REFUSAL OF PLANNING PERMISSION

APPLICATION NO. 2020/0670

Proposal Construction of overspill car park and access track.

At Spicer House, Spicer House Lane, Ingbirchworth, Barnsley, S36 7GG

OVERSPILL CAR PARKING FACILITY - SPICER HOUSE
 SPICER HOUSE LANE INGBIRCHWORTH S36 7GG

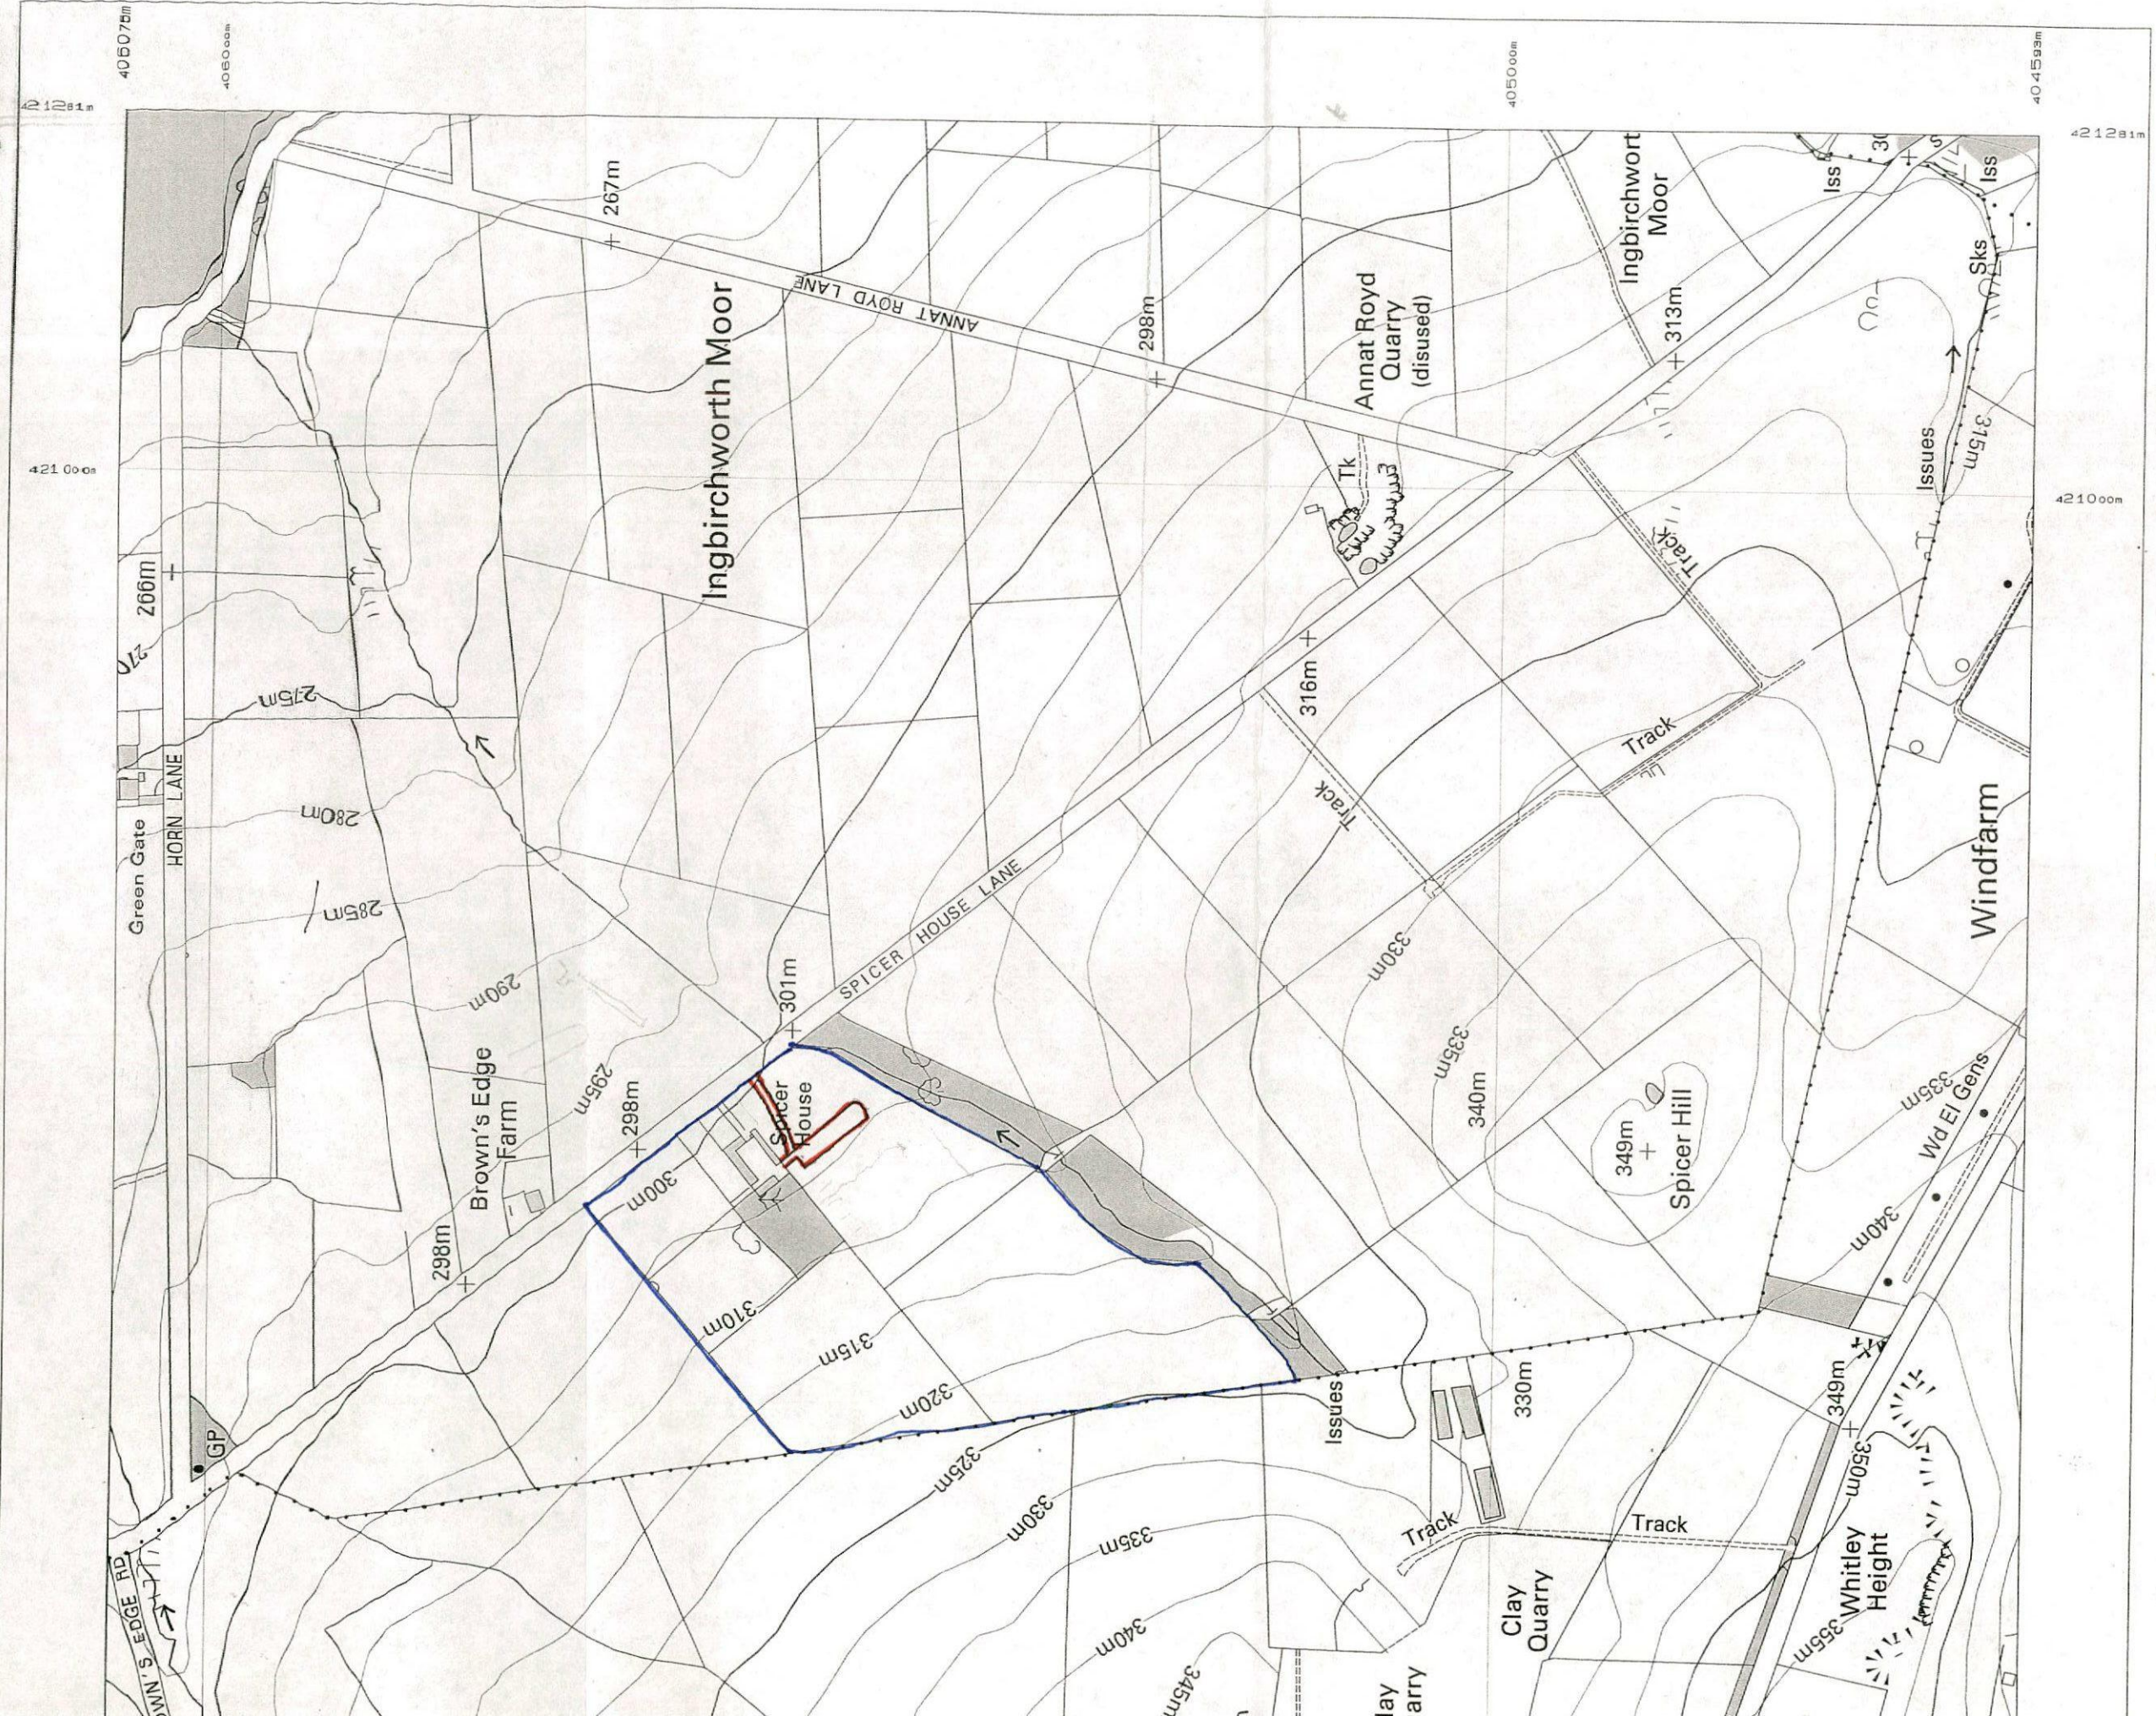
- 1 The site lies within the Green Belt on the approved Barnsley Local Plan. In the opinion of the Local Planning Authority, the proposed access road and 70 space car park would cut across an open field with a large area of hard surfacing, resulting significant detriment to the visual amenity and character of the Green Belt. The proposal is therefore not considered to preserve the openness of the Green Belt and would conflict with the purposes of including land within it. As such it would be classed as inappropriate development and very special circumstances have not been clearly demonstrated which outweigh the significant harm to the visual amenity and openness of the Green Belt contrary to Local Plan Policy GB1 and paragraphs 143, 144 and 146 of the NPPF.
